**Planning Department  
Transportation Development Services**

**Re: Commercial & Apartment Building – Phase I  
4419 4<sup>th</sup> St., NW  
Traffic Circulation Layout  
Engineer's/Architect's Stamp dated 10-15-15 (G14-D066)**

Based upon the information provided in your submittal received 10-15-15, the above referenced plan cannot be approved for Building Permit until the following comments are addressed:

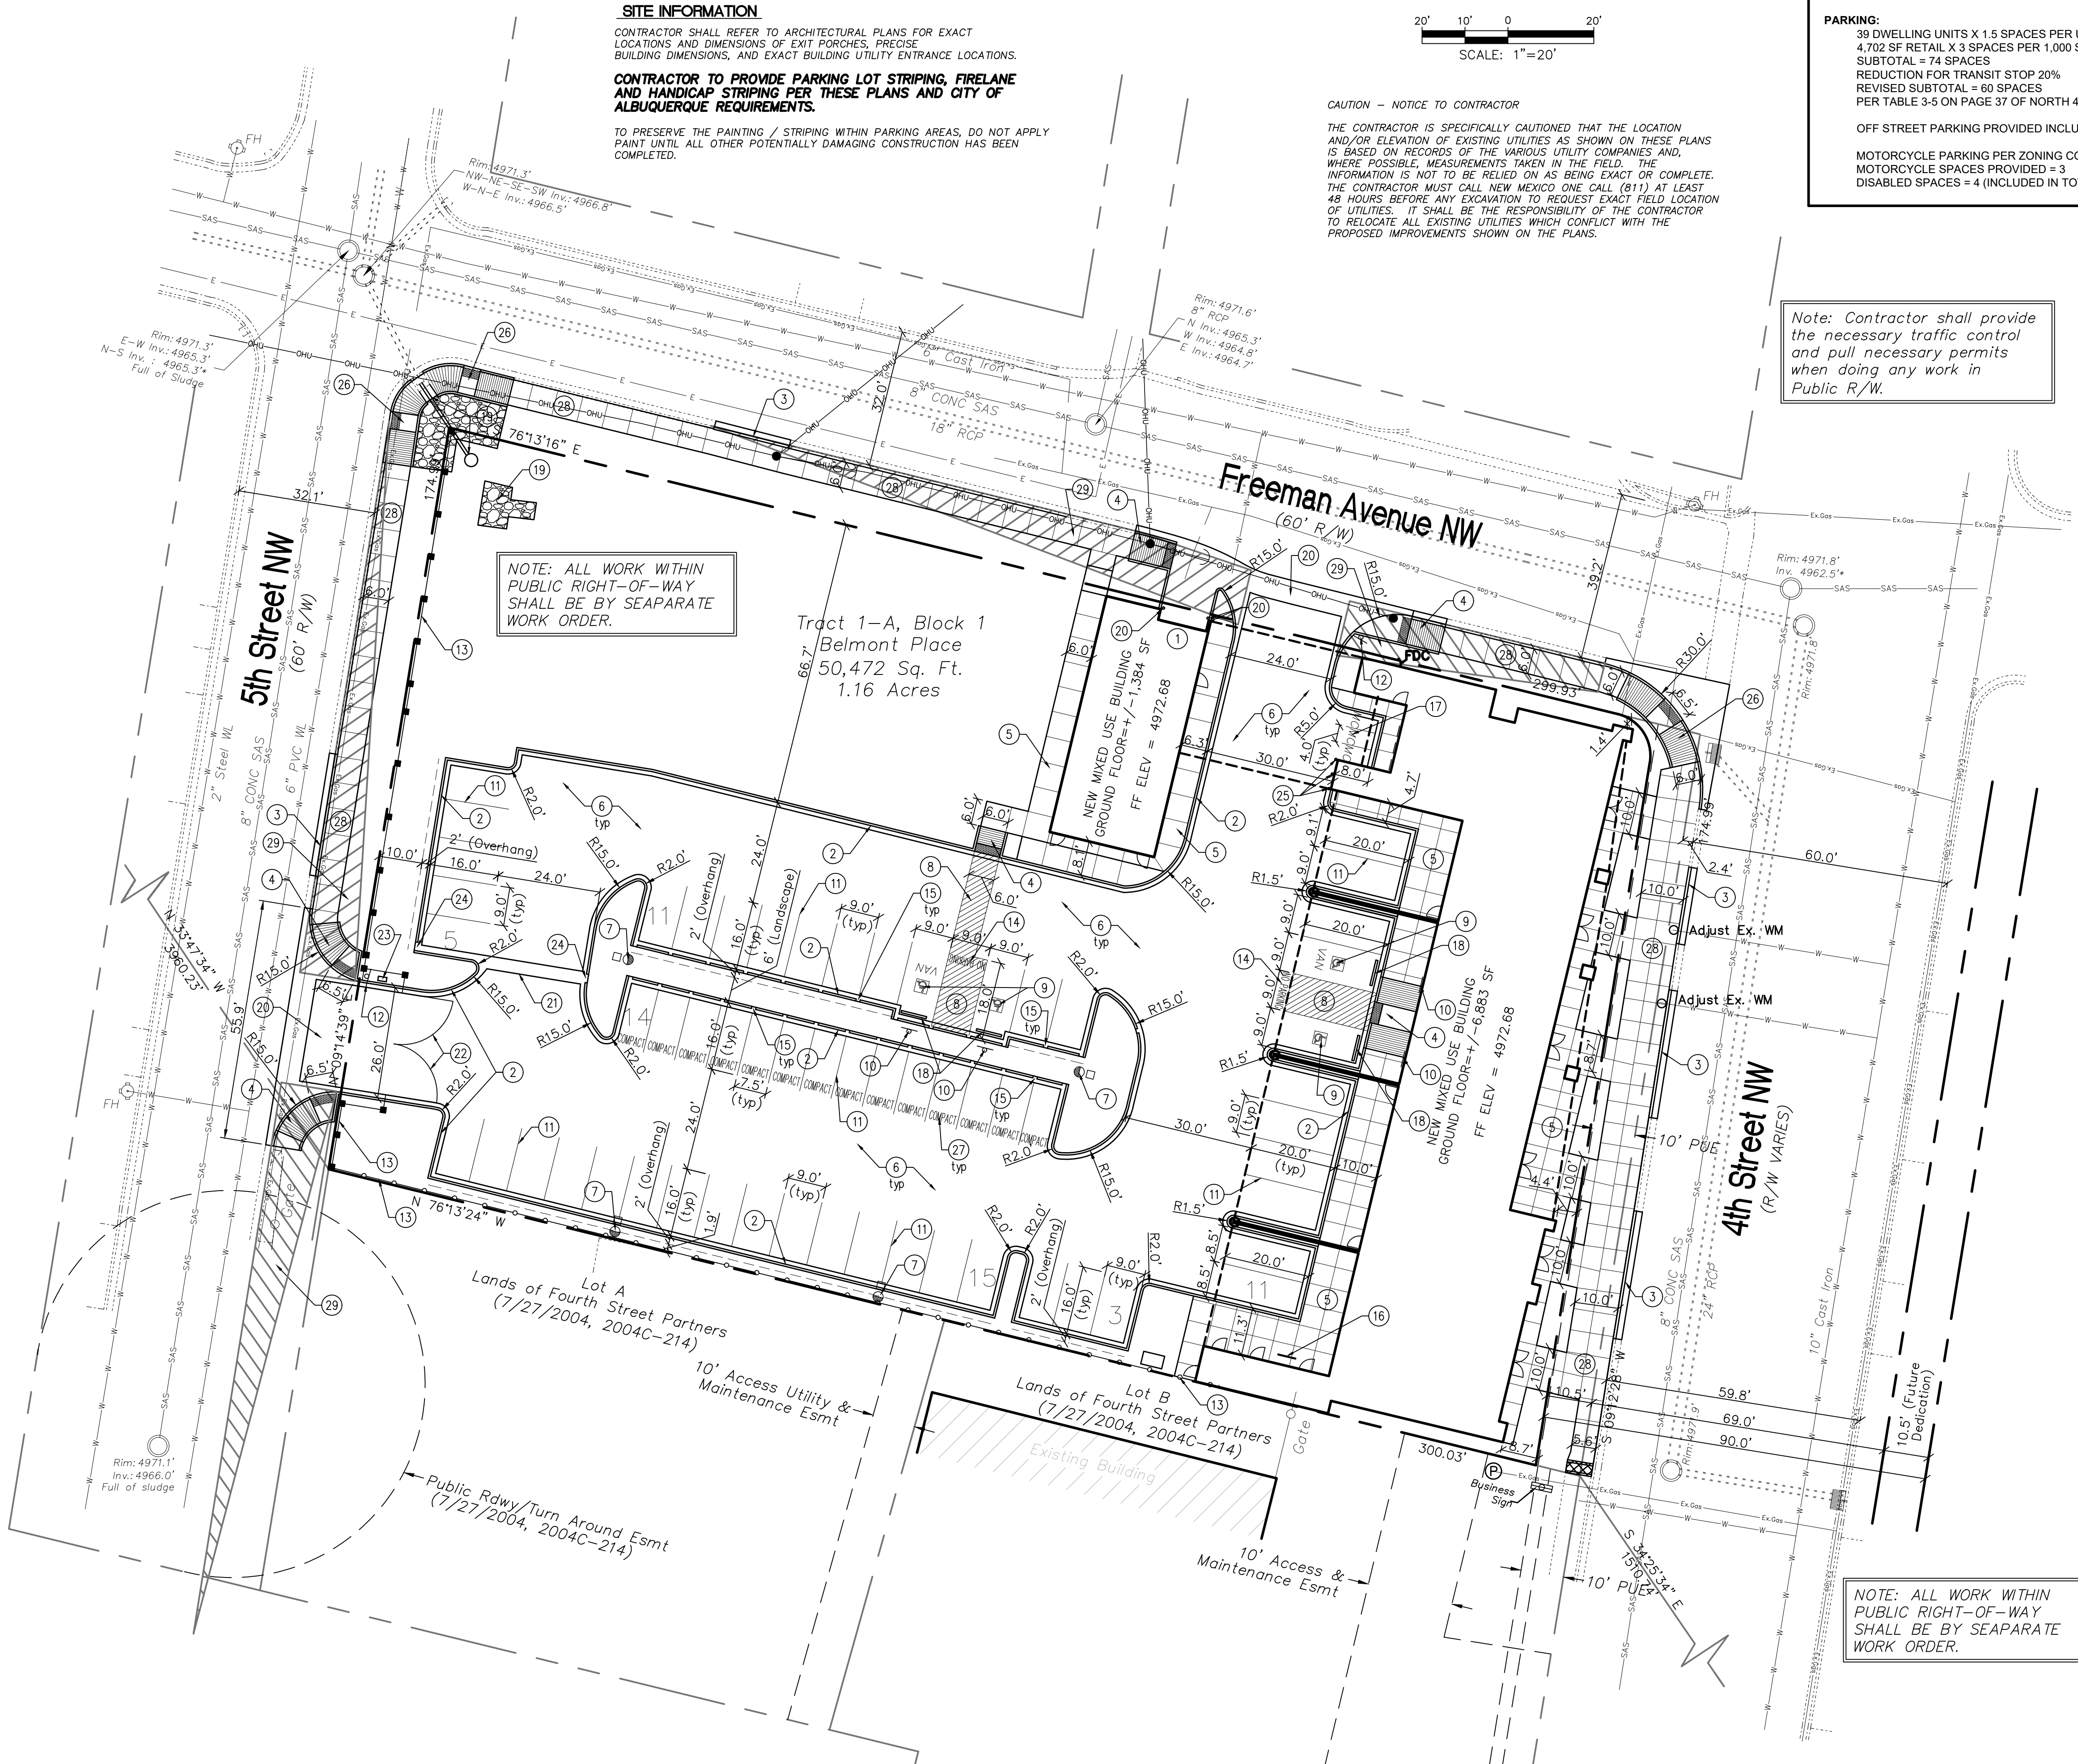
1. Per the DPM, a 6 ft. wide ADA accessible pedestrian pathway is required from the public sidewalk to the building entrances. Clearly detail ADA pathway from both Freeman Ave. and 4<sup>th</sup> St. to proposed building on the east end of the proposed project fronting 4<sup>th</sup> St.

2. Per the DPM, a 6 ft. wide ADA accessible pedestrian pathway is required from the HC parking stall access aisles to the building entrances. Please detail ADA accessible pedestrian pathway from parking island ADA spaces to proposed mixed used building at the east end of the project site. Clearly detail the pathway from the ADA pathway to the proposed mixed used building on the east end of the project. The ADA pathway detailed on the drawing is 5 ft. wide and only provides a pathway to proposed mixed use building to the north.

3. Design delivery vehicle route needs to be shown.
4. Service vehicle and/or refuse vehicle maneuvering must be contained on-site; provide a copy of refuse approval. Please detail location and refuse container.

5. Please provide a sight distance exhibit (see the *Development Process Manual, Chapter 23, Section 3, Part D.5 Intersection Sight Distance*). Please show this detail for drive pad entrances/exits on 5<sup>th</sup> St. and Freeman Ave.

6. Please add the following note to the clear sight triangle: "Landscaping and signage will not interfere with clear sight requirements. Therefore, signs, walls, trees, and shrubbery between 3 and 8 feet tall (as measured from the gutter pan) will not be acceptable in this area."
7. Unused curb cuts must be replaced with sidewalk and curb & gutter. A build note must be provided referring to the appropriate City Standard drawing.
8. Please include two copies of the traffic circulation layout at the next submittal.
